**KIRKLEES METROPOLITAN COUNCIL  
INVESTMENT & REGENERATION SERVICE**

**DELEGATED DECISION TO DETERMINE PLANNING APPLICATIONS**

Reference No:	<b>2023/62/91474/W</b>
Site Address:	94, New North Road, Edgerton, Huddersfield, HD1 5QP
Description:	Alterations to building and erection of bin store (within a Conservation Area)
Recommending Officer:	Laura Yeadon

**DECISION – CONDITIONAL FULL PERMISSION**

scale 1:100 date 03/2023 sheet size A2 dwg. no. 23/874/06c

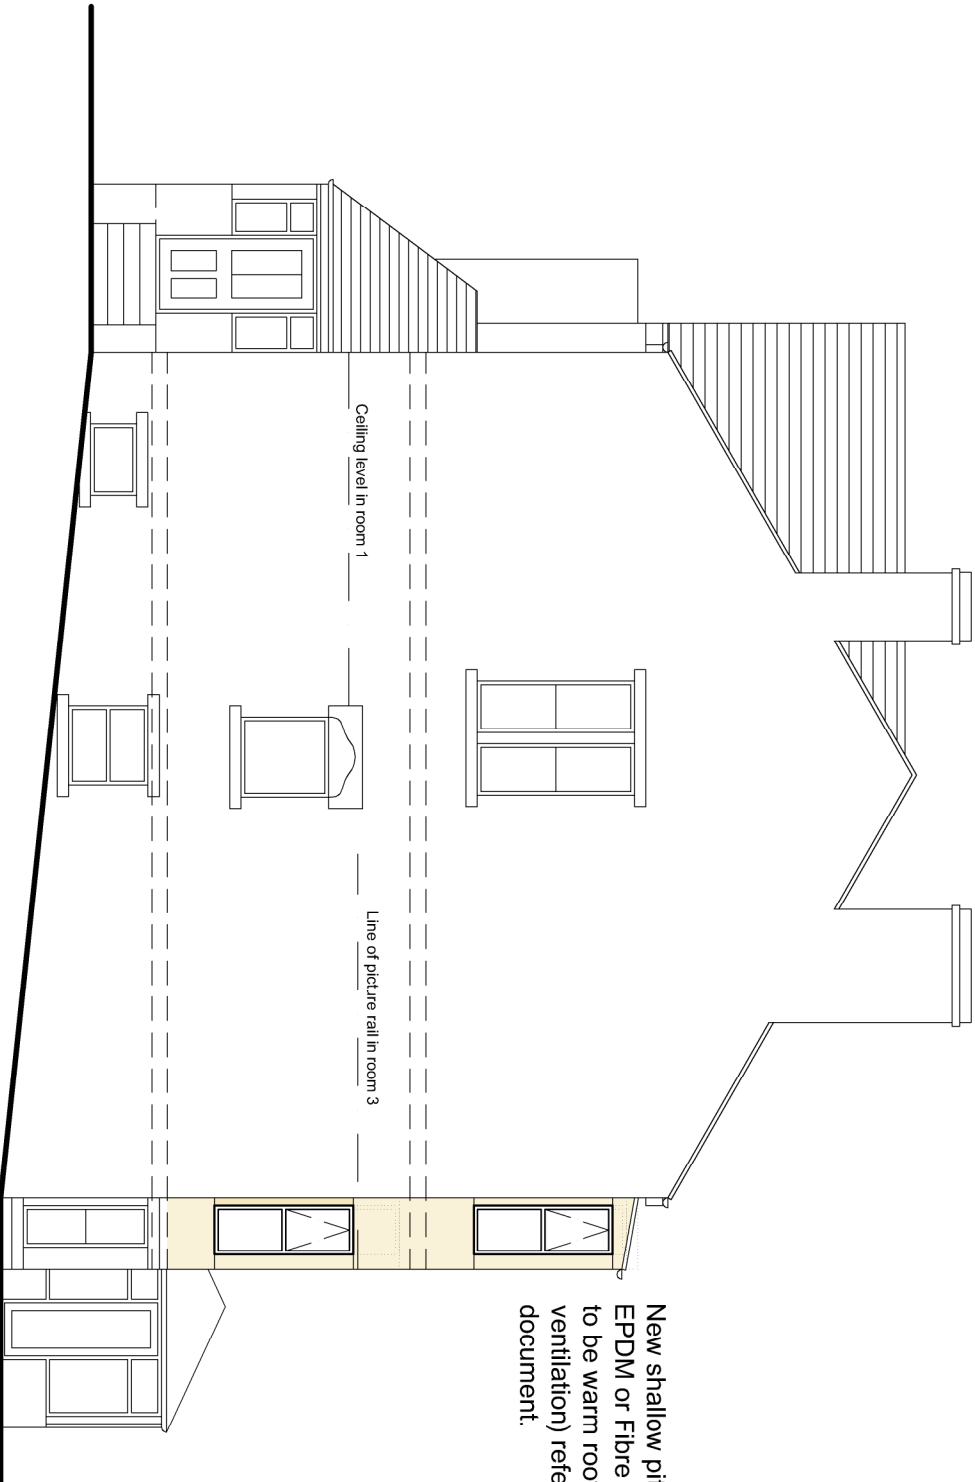
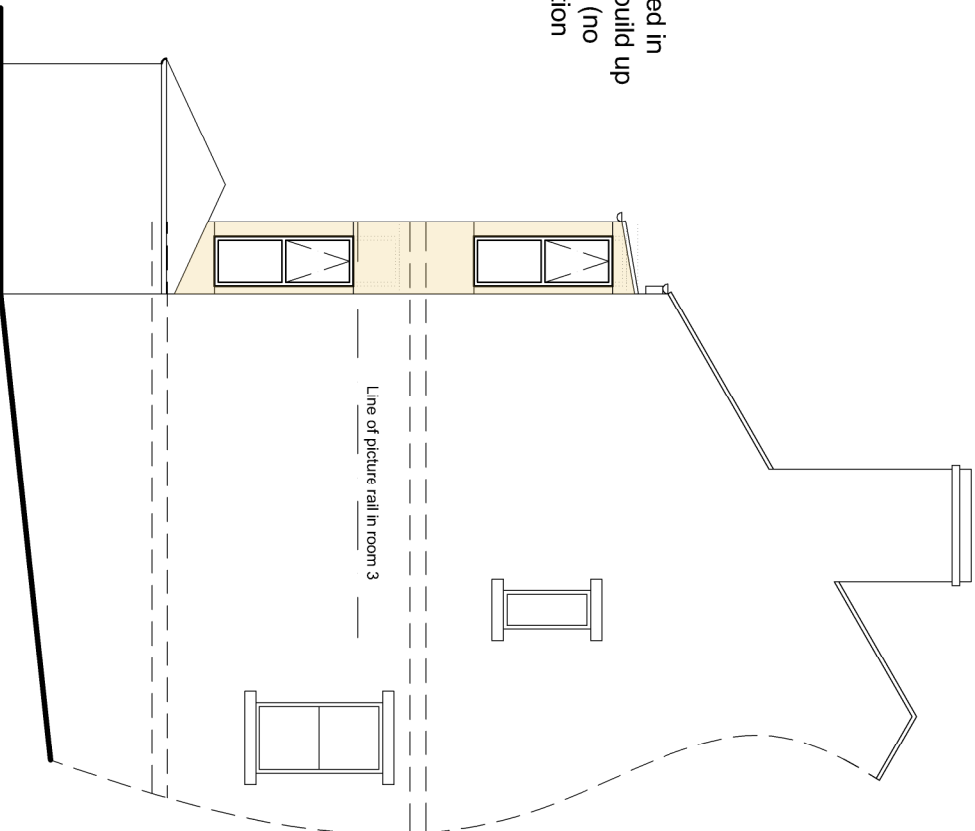
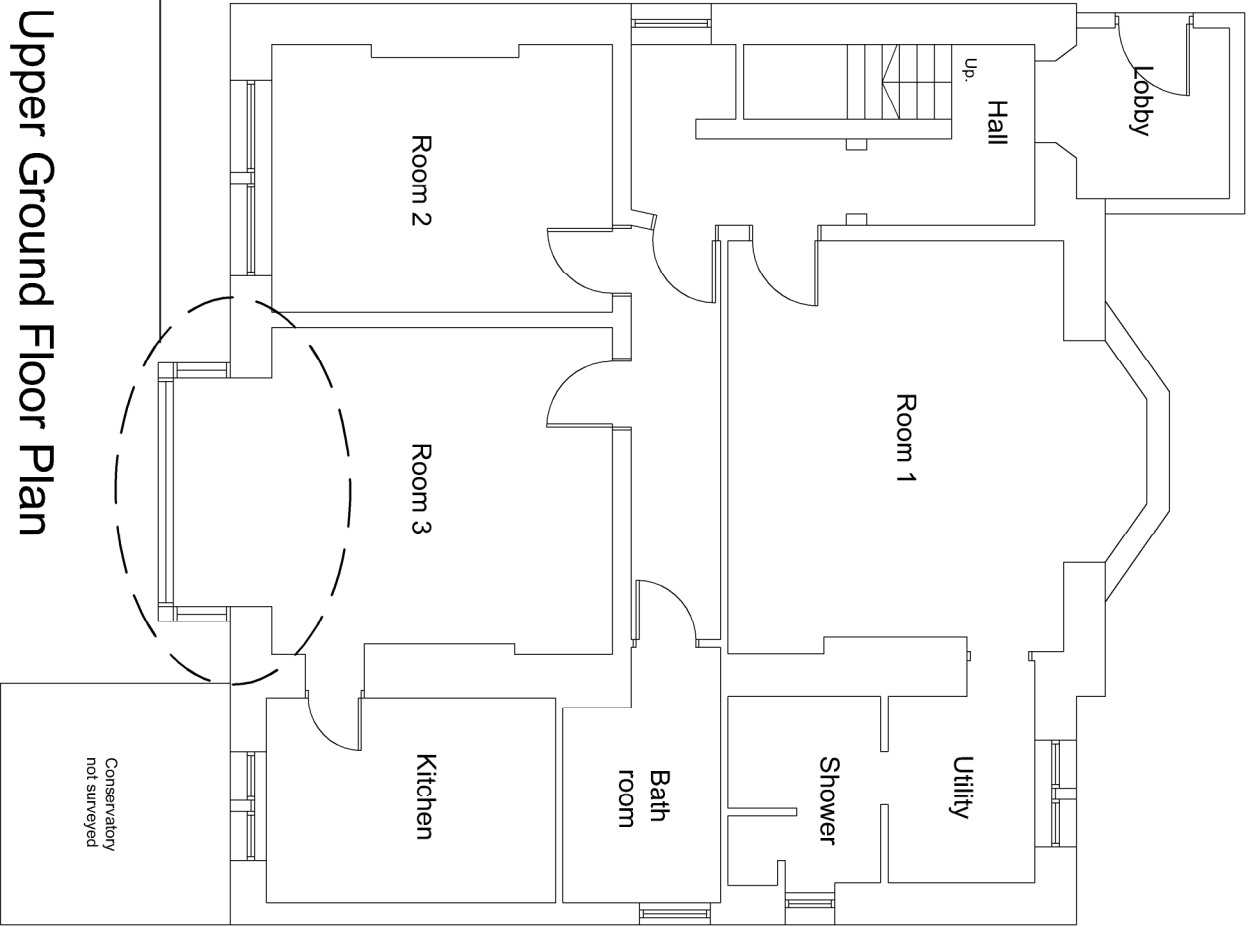
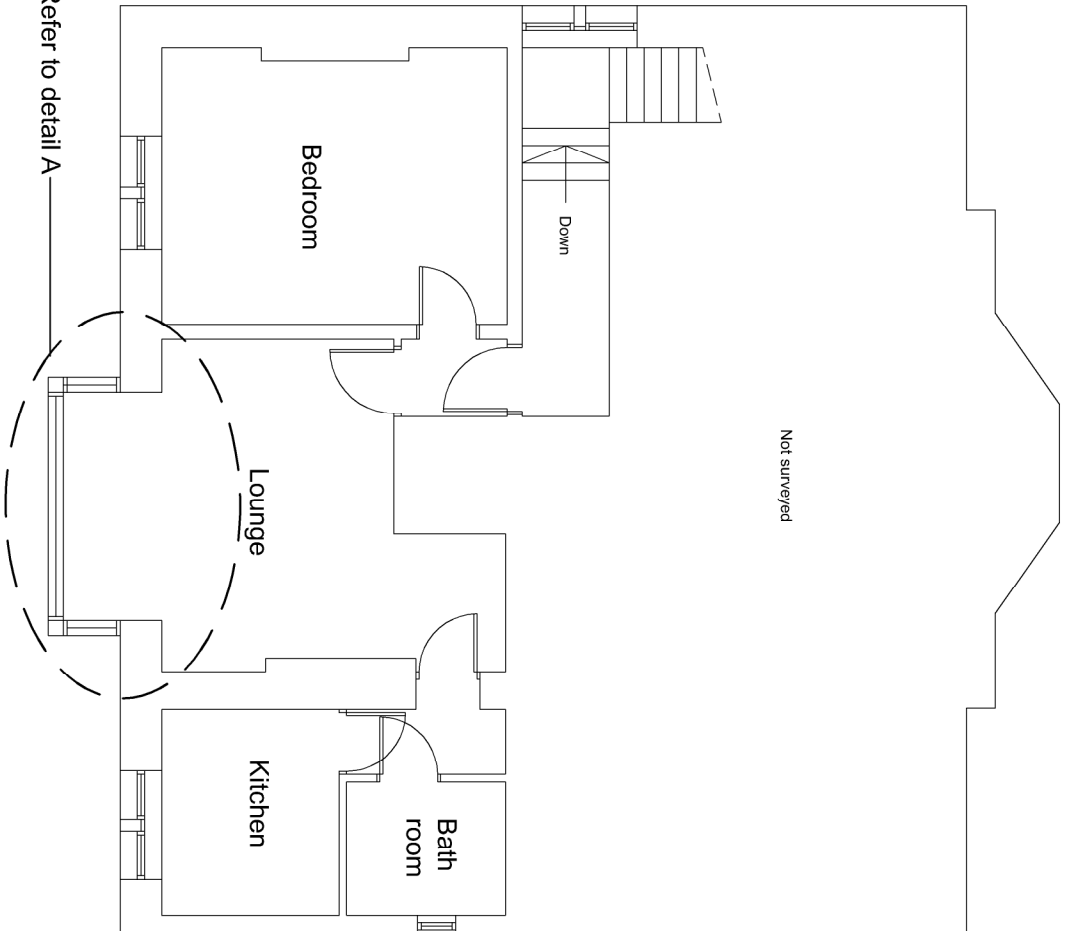
K.C Conservation and Design – initial concerns raised with regards to the removal of the chimney stack, the redesign of the openings and the large areas of panelling. Following lengthy discussions and the submission of

Initial concerns were raised from the Council's Conservation and Design Team with specific regard to the loss of the chimney stack, the proposed fenestration details and the cladding details. Following discussions and email correspondence with the Agent and applicant, details with the Team have been agreed including amended fenestration details, the retention of the chimney stack and the use and colour of the proposed plank cladding which shall be conditioned to be Arctic White.

amended plan 23/874/06C along with brochure details, the proposal is now acceptable subject to the panelling being conditioned to be Arctic White as contained within the submitted brochure.

3. The external cladding to the bay window to the rear of the building shall be finished in plank cladding which shall be Hardie Arctic White and shall thereafter be retained for the lifetime of the development.

Bin Store Plan

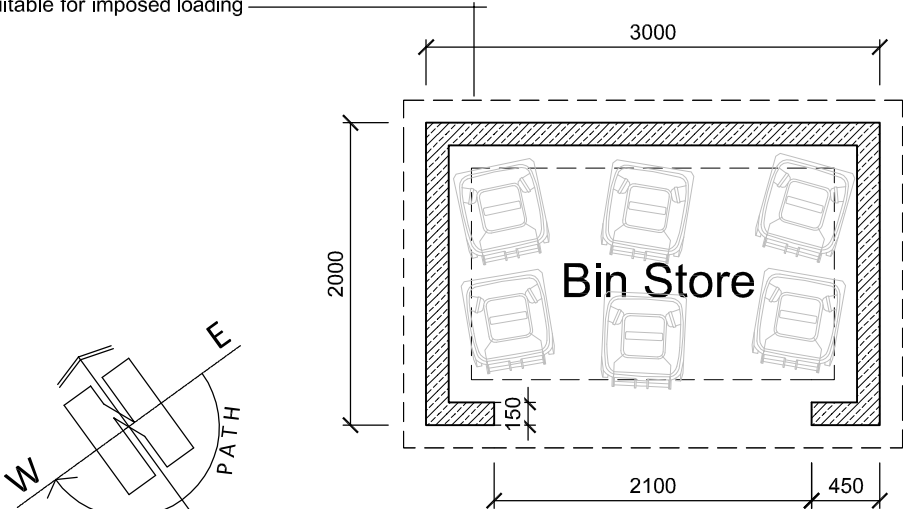
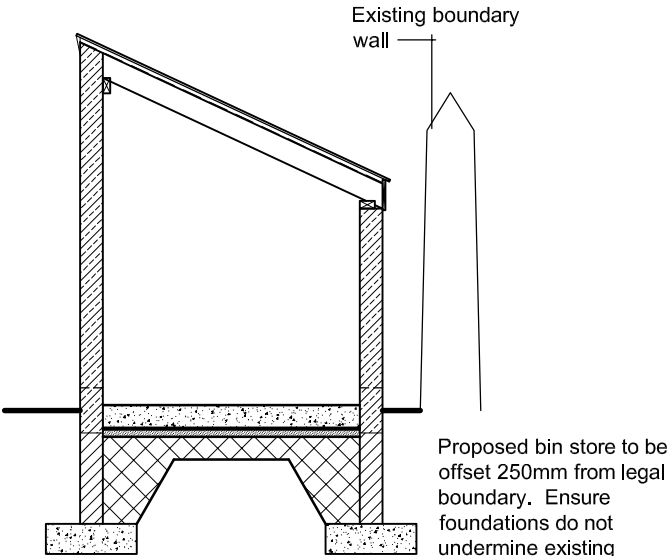
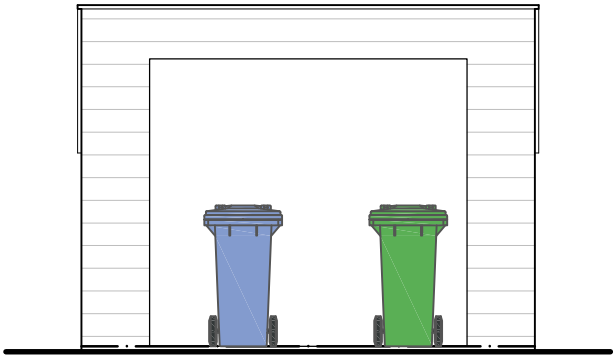
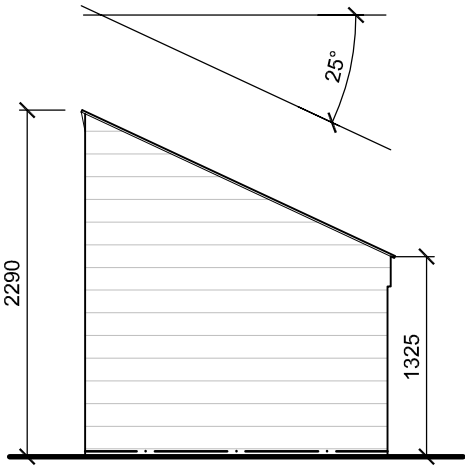
There is a proposed detached bin store which would be located behind the existing conservatory to the rear of the property. The building would be 3m x 2m with a mono-pitched roof that would have an eaves height of 1.3m and overall height of 2.3m. The walls would be constructed from coursed sandstone with the roof being blue slate. The store would have an open frontage on the south elevation.

4. The materials of construction of the walls of the bin store shall be natural stone and the materials of construction of the roof shall be blue slates. The materials of construction shall be retained thereafter.
